August 21, 2019

Re: Restaurant with drive thru
700 Coors Blvd NW Albuquerque NM 87105
Traffic Circulation Layout
Engineer's/Architect's Stamp 08-15-2019(J11D039)

Drawing No. C6.1

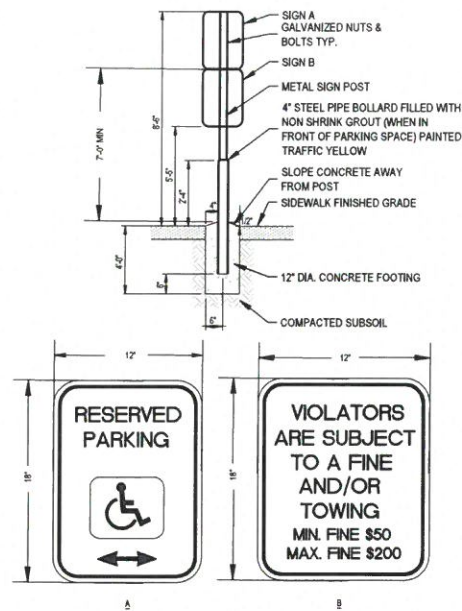
2. Please consider narrowing the access to the site and show driving lanes.
3. The ADA accessible parking sign must have the required language per 66-7-352.4C NMSA 1978 **"Violators Are Subject to a Fine and/or Towing."** Please call out detail and location of signs.

- 11. provide a copy of refuse approval.
- 12. Show the clear sight triangle and add the following note to the plan:
"Landscaping and signage will not interfere with clear sight requirements. Therefore, signs, walls, trees, and shrubbery between 3 and 8 feet tall (as measured from the gutter pan) will not be acceptable in the clear sight triangle.

- 13. **Unused curb cuts must be replaced with sidewalk and curb & gutter.** A build note must be provided referring to the appropriate City Standard drawing.

- 14. Add a note stating "All broken or cracked sidewalk must be replaced with sidewalk and curb & gutter." A build note must be provided referring to the appropriate City Standard drawing.

INVERTED U BICYCLE RACK DETAIL
NTS

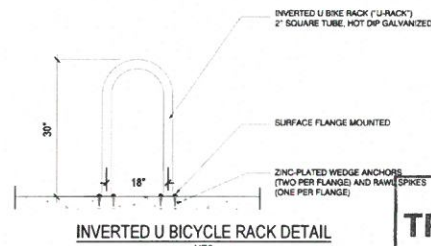
7. All bicycle racks shall be designed according to the following guidelines:
 - a. The rack shall be a minimum 30 inches tall and 18 inches wide.

- b. The bicycle frame shall be supported horizontally at two or more places. Comb/toaster racks are not allowed.
 - c. The rack shall be designed to support the bicycle in an upright position. See the IDO for additional information.

- d. The rack allows varying bicycle frame sizes and styles to be attached.
 - e. The user is not required to lift the bicycle onto the bicycle rack.
 - f. Each bicycle parking space is accessible without moving another bicycle.

- 8. Bicycle racks shall be sturdy and anchored to a concrete pad.
- 9. A 1-foot clear zone around the bicycle parking stall shall be provided.
- 10. Bicycle parking spaces shall be at least 6 feet long and 2 feet wide.

"MOTORCYCLE PARKING ONLY" SIGN DETAIL
NTS

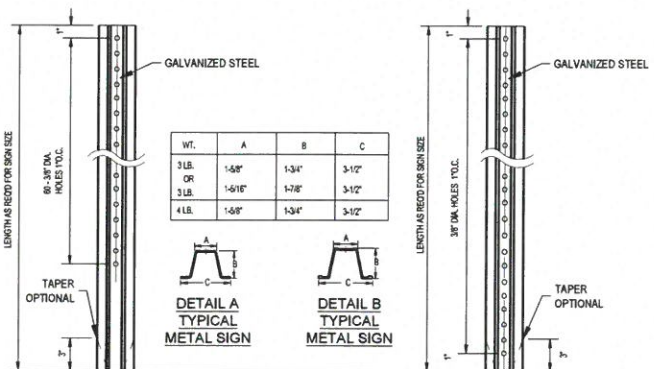
5. ADA curb ramps must be updated to current standards and have truncated domes installed.
6. Motorcycle parking spaces shall be designated by its own conspicuously posted upright sign, either free-standing or wall mounted per the zoning code.
